**WEST SUSSEX COUNTY COUNCIL  
STRATEGIC PLANNING CONSULTATION**

**SUBJECT: LU/234/16/RES - Application for reserved matters relating to access, appearance, landscaping, layout and scale of the previously approved LU/63/11/. This application affects a Public Right of Way.**

**LOCATION: Fitzalan Link Road, Worthing Rd (A259), East Street, Littlehampton, West Sussex.**

**Additional Information.**

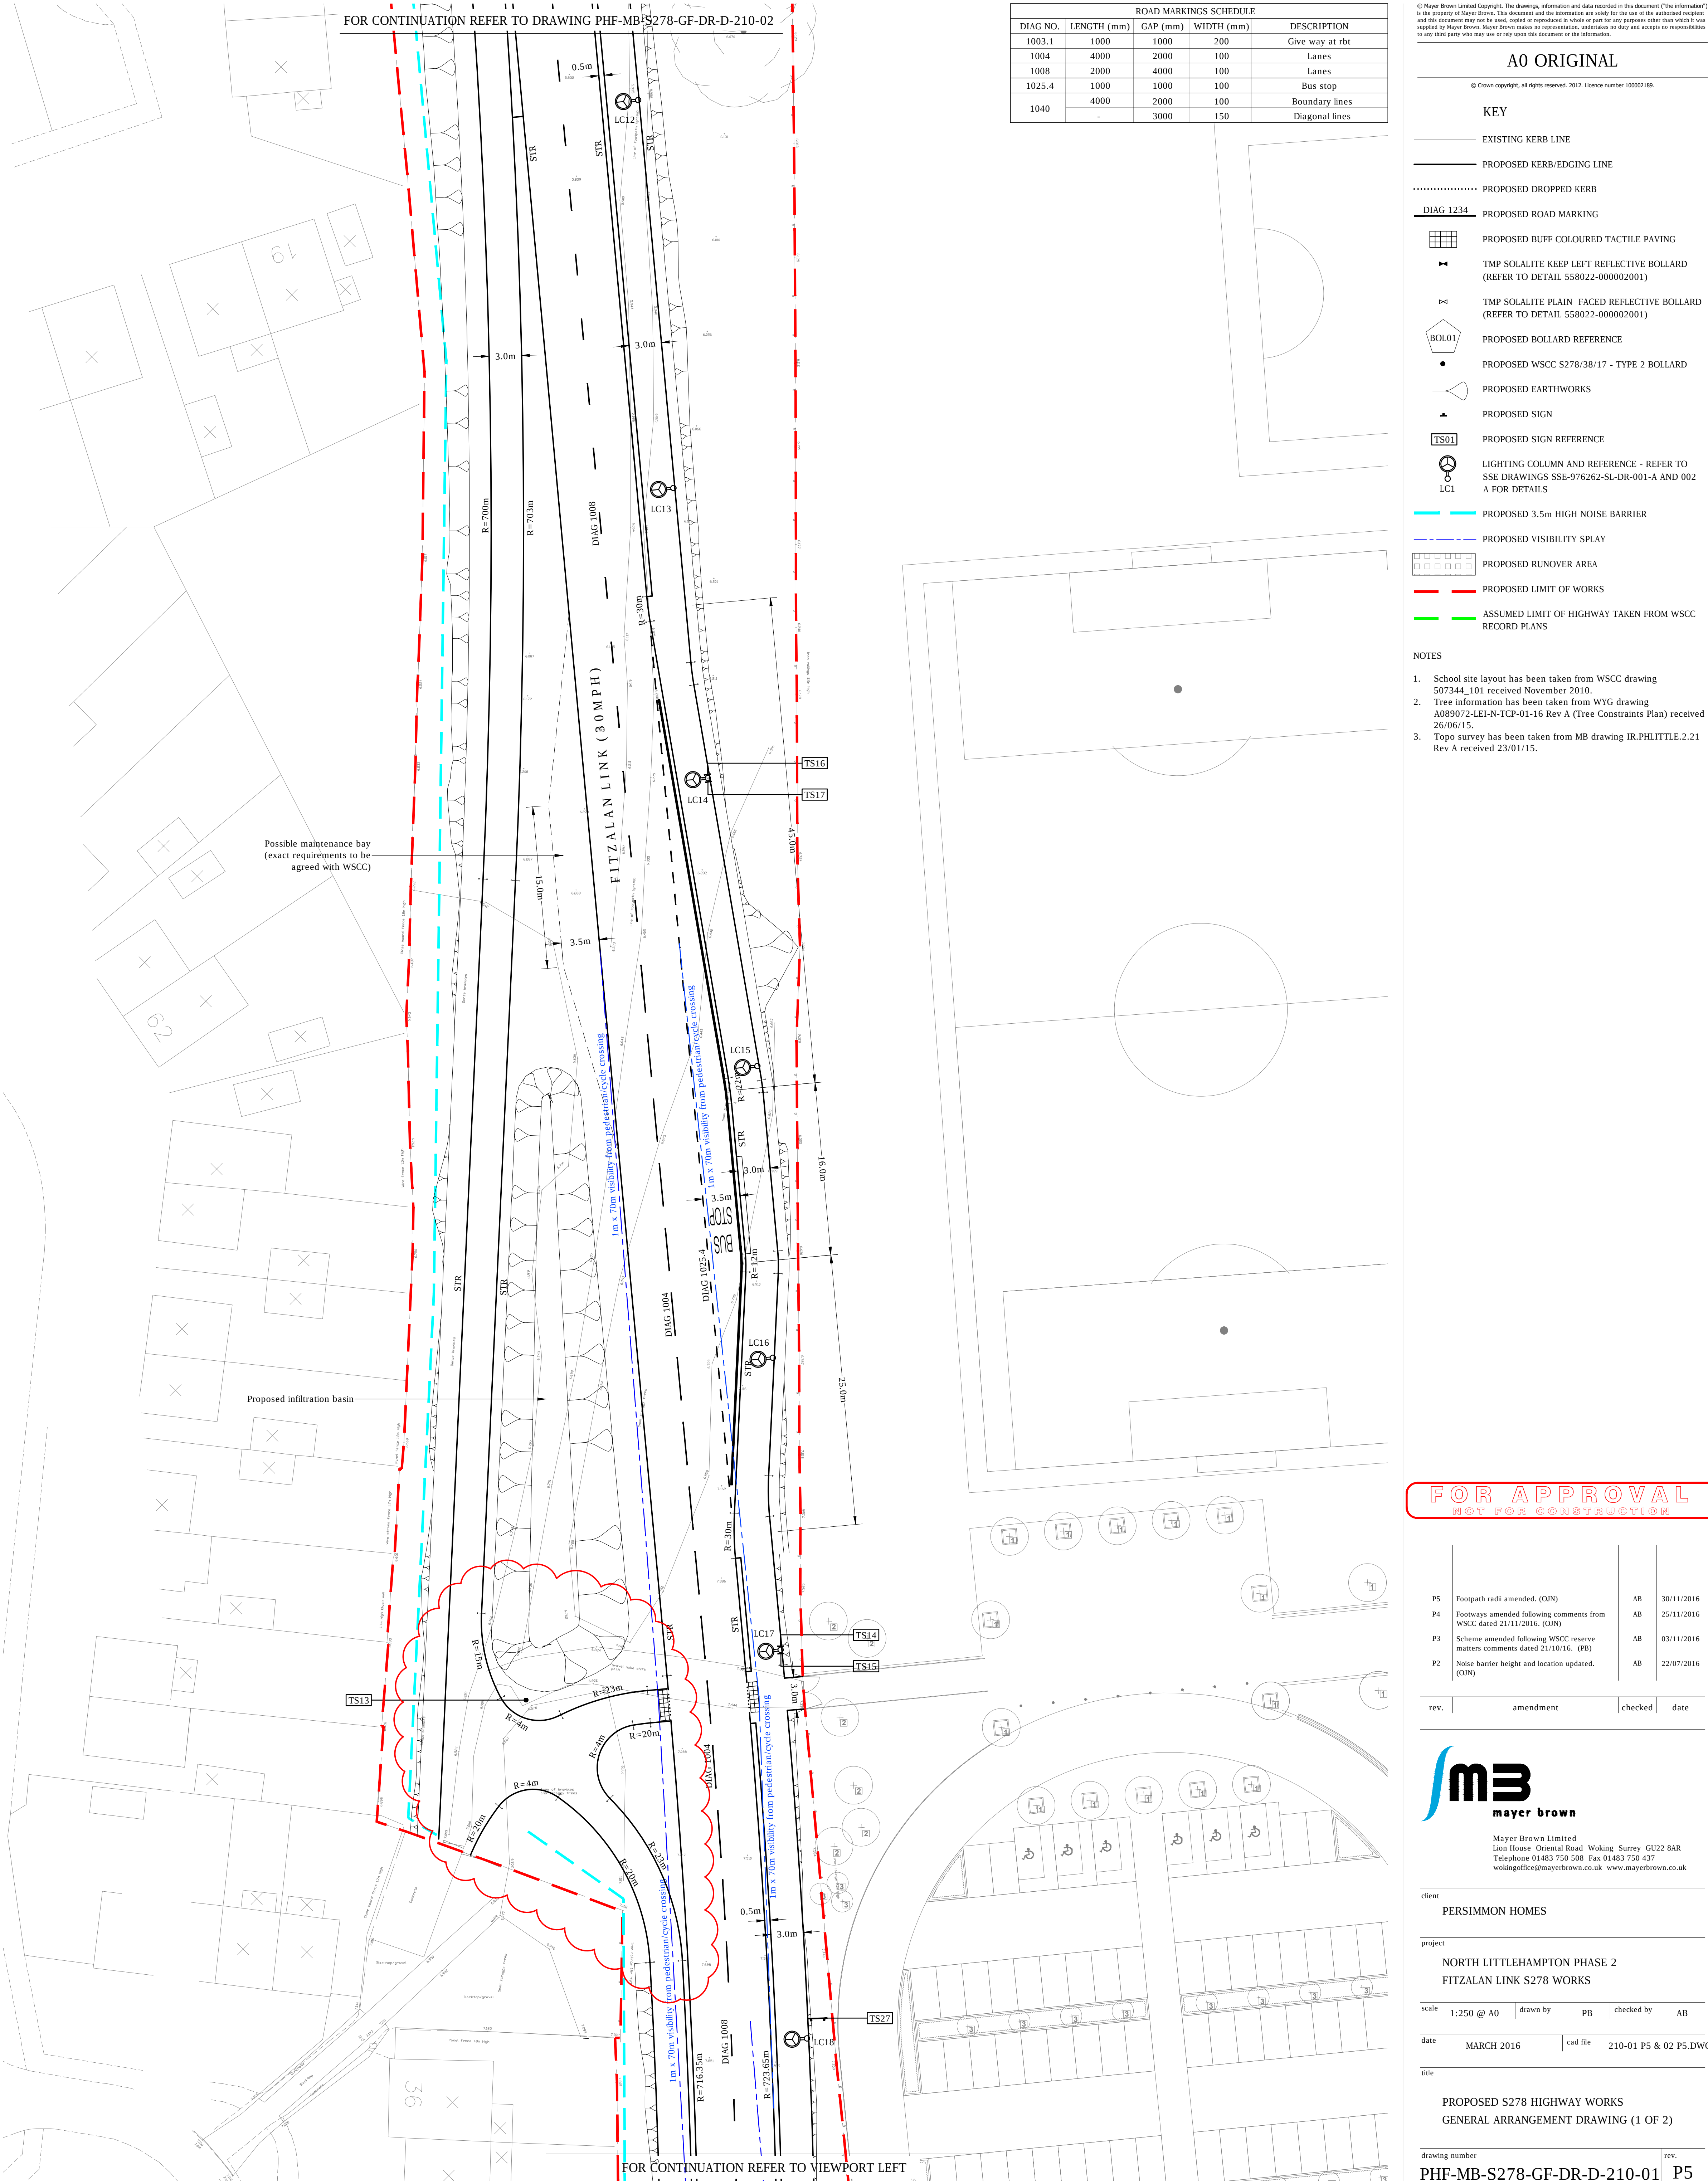
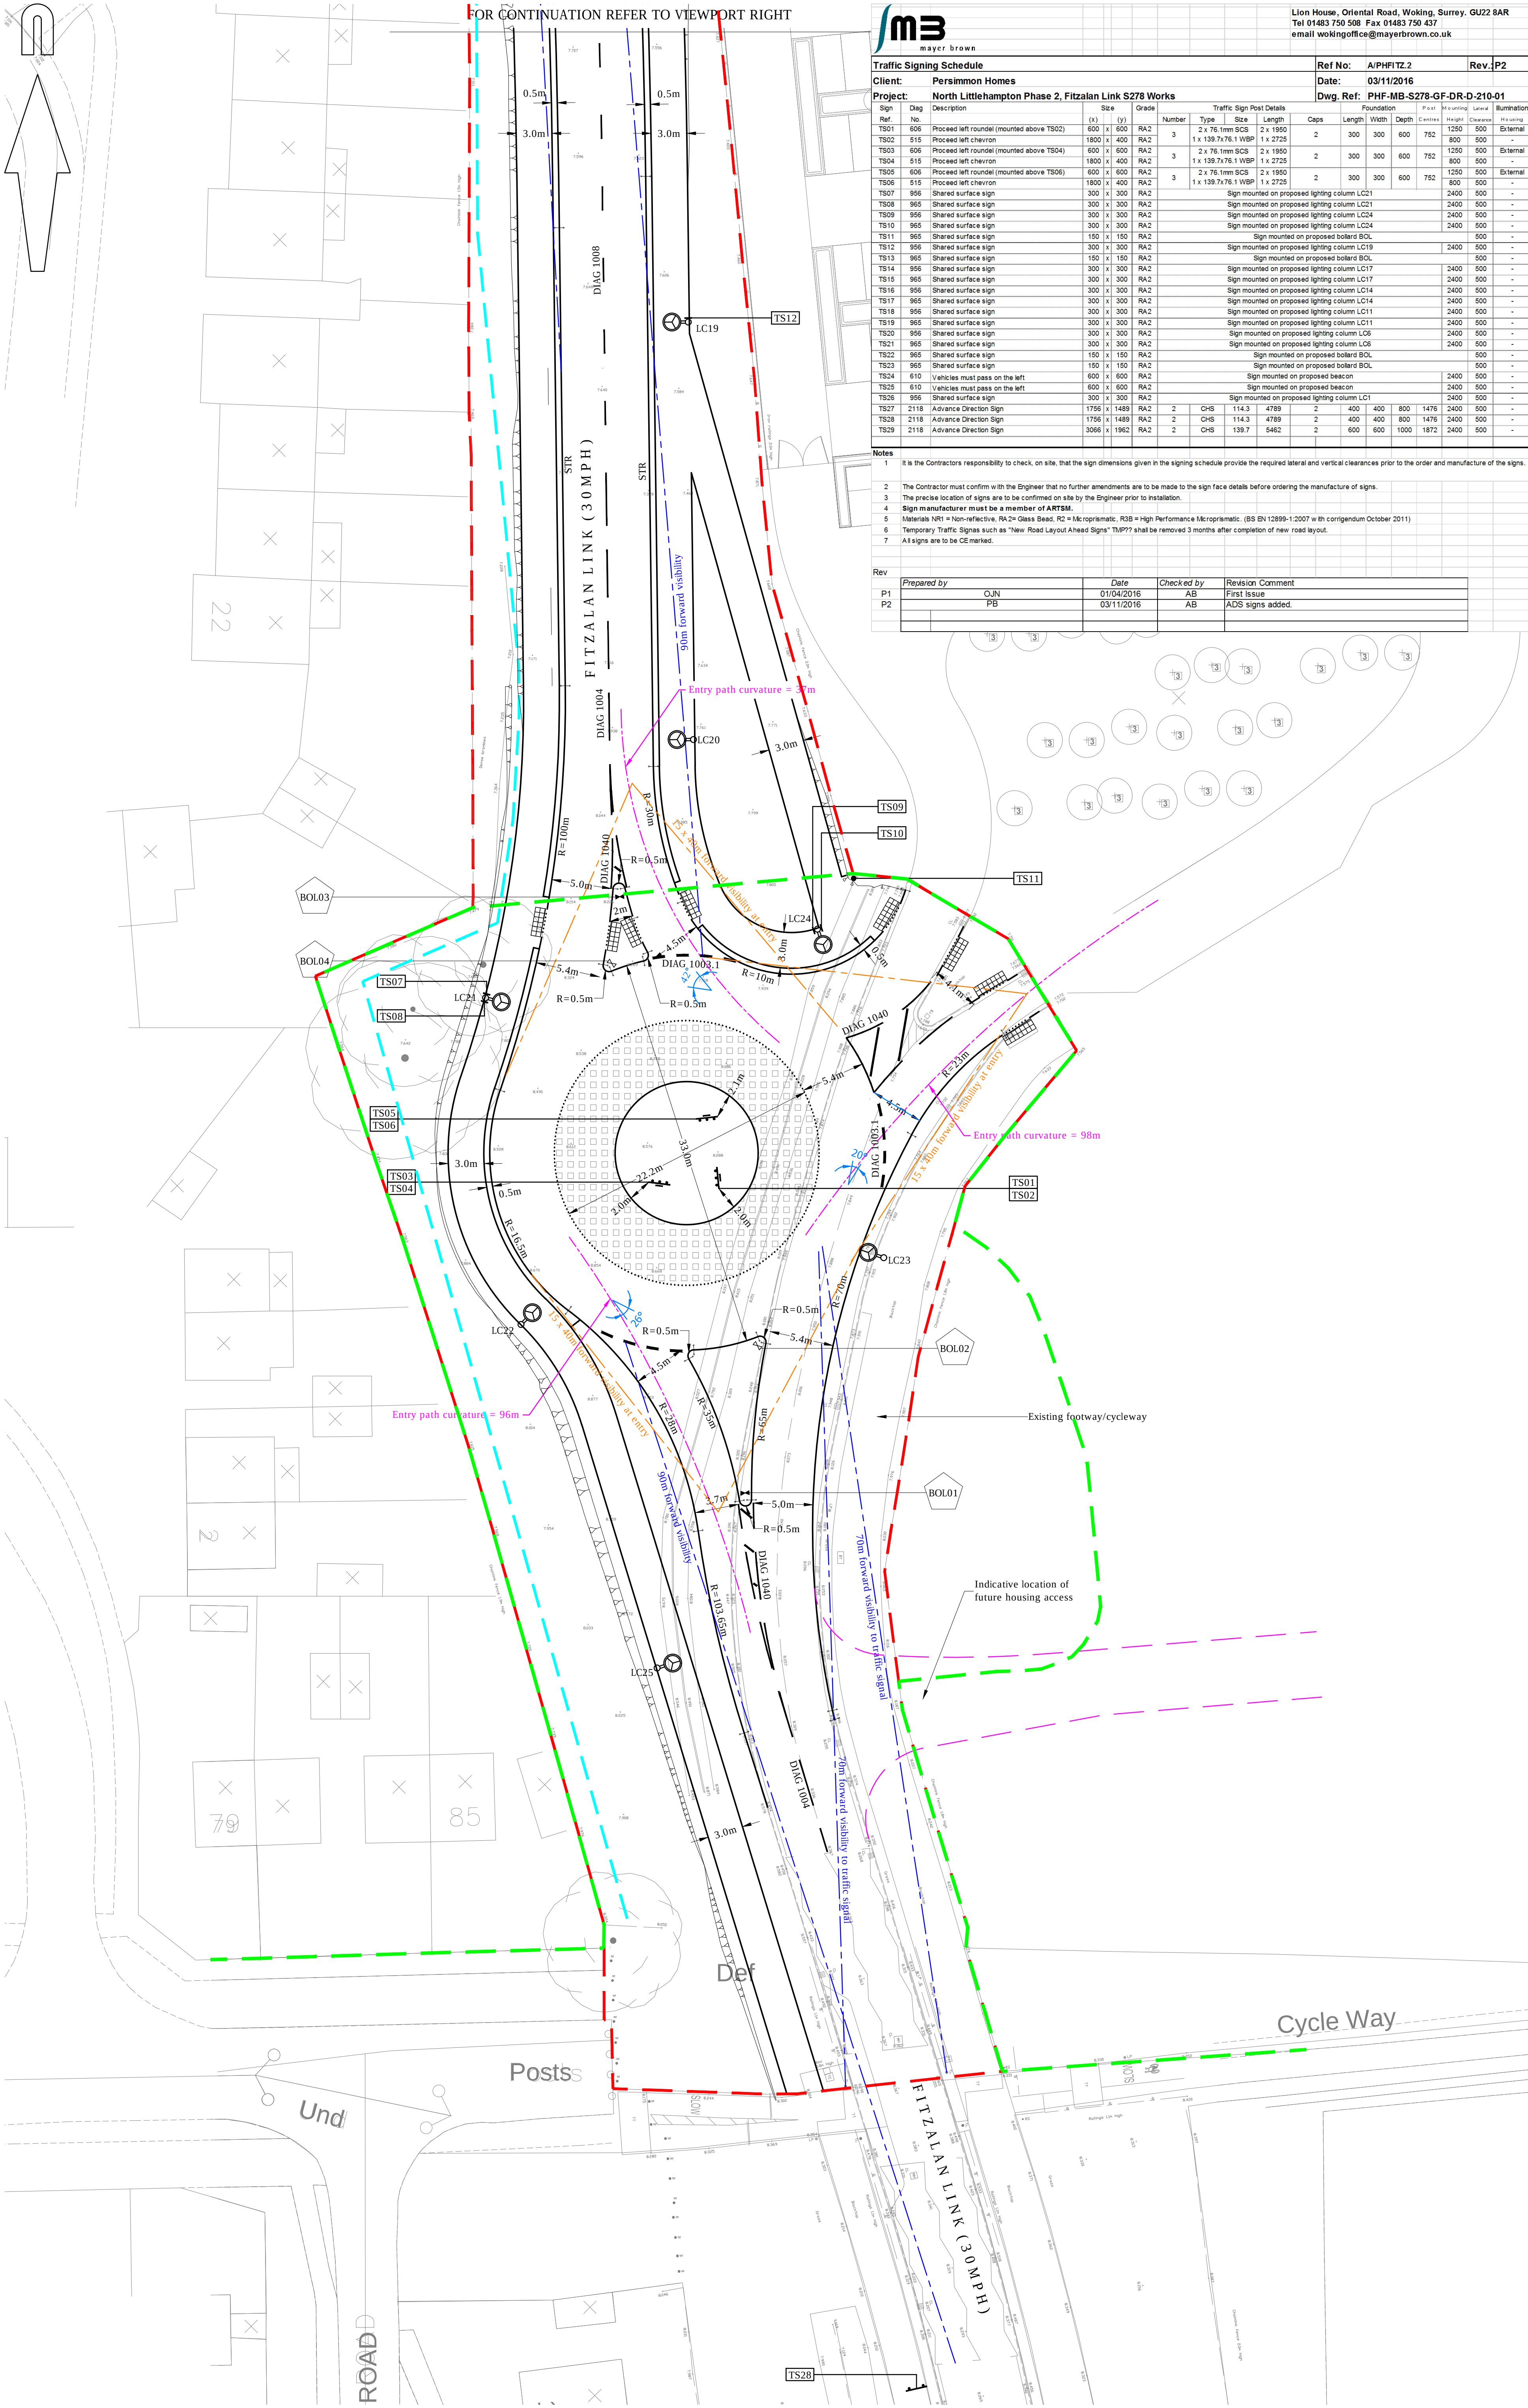
The legal line of the highway south of the Persimmon land is as shown in pink of the extract found below. As such, this is the line that should be used. This is now shown on the latest version of the application drawings PHF-MB-S278-GF-DR-D-210-01 Rev P8 and PHF-MB-S278-GF-DR-D-210-02 Rev P8. At the detailed design stage, the applicant will need to provide appropriate signage, lining, lighting, tactile paving and fencing etc. Also, changes to any existing Public Rights of Way (PRoW) must be undertaken in accordance with WSCC PRoW procedures (also see below).

Location as shown on drawing PHF-MB-S278-GF-DR-D-210-01 Rev P8.

Academy roundabout northern traffic island has a tactile paved crossing point. Given that it is narrow (the tactile paving on the drawing appears to 'meet'), consideration should be given at the S38/S278 stage to widening it or adjusting the position of the tactile paving (if possible) to improve width for pedestrians. However, in doing this the applicant should also ensure that the swept-path of vehicles can still adequately negotiate the roundabout without compromising safety for pedestrians on the island. The applicant has agreed to review this to see what changes can be made to accommodate a larger island as requested at the detailed design stage.

Recommend that at the detailed design stage, the cycleway on the east side be locally flared at the controlled crossing to provide additional width for waiting pedestrians and cyclists. Also, that LC 17 be moved to the very back of the space available, away from the area of conflict where there would be interaction between pedestrians and cyclists. WSCC recommend that the crossing width be increased beyond the minimum so as to provide more space for waiting pedestrians in order to help keep the cycle route clear. The location of the control box must be carefully considered to avoid obstruction for users and visibility. Finally, it is recommended that corner radii be applied between the cycle paths at the school exit next to the crossing and that pedestrian and cycle intervisibility is

Both northbound and southbound bus stops and laybys are now shown. Where possible (and again at the detailed design S38/S278 stage), additional path width should be provided at *both* bus stops to allow passengers to wait clear of the cycle path. Also, consideration to where possible bus shelters might be placed should be given at the detailed design stage, and what form these would take given the space available.
